Maritime &
Coastguard
Agency

Your reference: EN010119

Application by North Falls Offshore Wind Farm Limited (Ltd) for an Order Granting Development Consent for the North Falls Offshore Wind Farm.

Written Representation

Figure 4.3 Charted Galloper Recommended Ferry Route

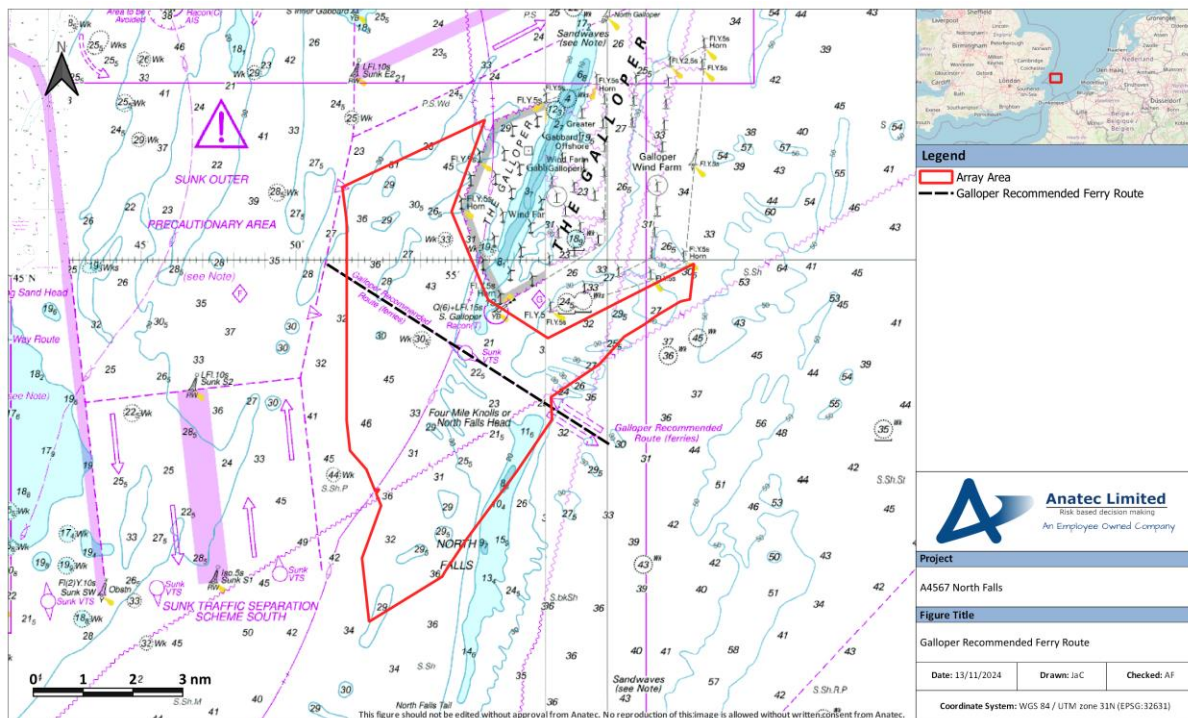
The southern array overlaps an IMO-adopted routeing measure, known as the Galloper Recommended Route, which was established in 2007 for the ferries operating between Harwich Haven ports and Ostend. As per our response to the PEIR consultation and Relevant Representation, it will require agreement with relevant operators, ports and IMO member nations, in particular the Belgian maritime administration, to remove the Recommended Route as an IMO-adopted routeing measure. If agreement cannot be reached firstly at the UK Safety of Navigation (UKSON) committee (UK's navigation policy steering group), and subsequently by IMO members, MCA will not be able to support the proposed North Falls offshore wind farm development. Approval to remove the Galloper Recommended Route from the IMO must be received before any construction can commence.

The applicant has conducted an additional navigation and environmental risk assessment on alternative routes vessels could take to Belgian ports. This assessment has been accepted and the Belgian maritime administration has indicated they could support the removal of the Galloper Recommended Route. If the project receives ministerial consent in Q1 2026, the proposal to remove the Recommended Route will be presented to UKSON in March/April 2026. If approved by UKSON, the proposal will be submitted six months (December 2026) before the Experts Group on Ships Routing at the International Maritime Organisation's (IMO) sub-committee on Navigation Communication Search and Rescue (NCSR) in May/June 2027. If the Experts Group agrees to the removal of the Recommended Route, the proposal will be submitted to the subsequent Maritime Safety Committee (MSC) 114, to be held in May 2028. Once accepted by MSC the removal of the Recommended Route will be in force within 4-6 months, therefore the earliest this can be expected is Q4 2028.

It is our position that a condition of consent must be included within the DCO/DML to ensure that no offshore construction that directly interacts with the Galloper Recommended Route can commence before the removal is in force.

Figure 7.1 Refinement of Array Area

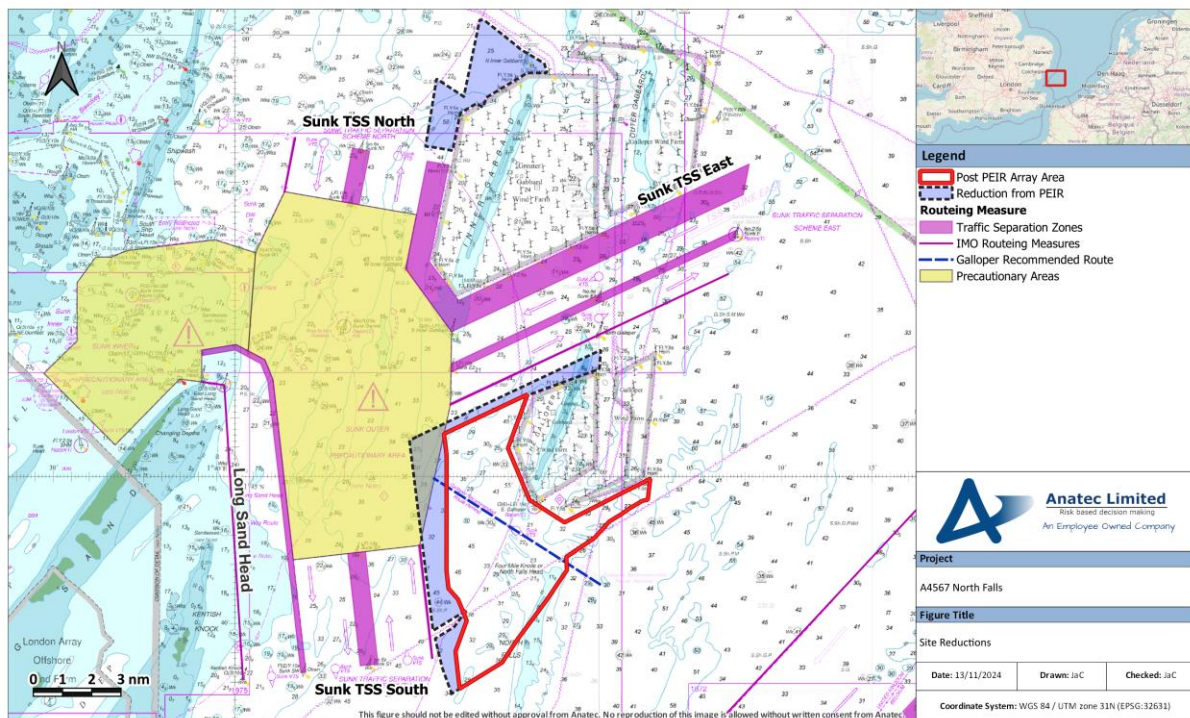
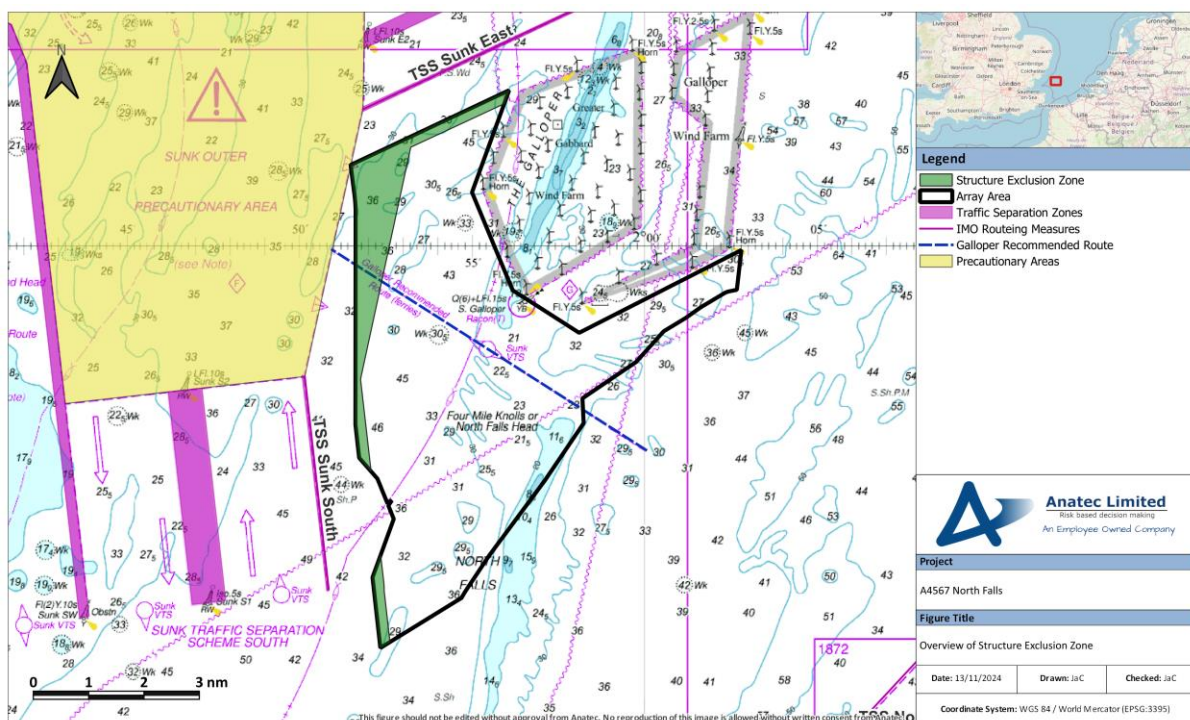
The removal of the northern array is welcomed for avoiding unacceptable risks to navigation safety. The Red Line Boundary (RLB) of the southern array was changed post-PEIR as presented in Figure 1-1 of the NRA to avoid encroaching into the International Maritime Organization (IMO) adopted Precautionary Area and to increase the distance from two IMO-adopted Traffic Separation Schemes. Whilst these distances do not meet the guidance within MGN654 for mitigating collision and allision risks, a Structures Exclusion Zone (SEZ) is proposed to ensure no surface piercing or above-surface infrastructure will be installed within 1NM of the IMO-adopted traffic routeing measure boundaries. This has been agreed by MCA as a necessary mitigation measure for reducing navigational risks.
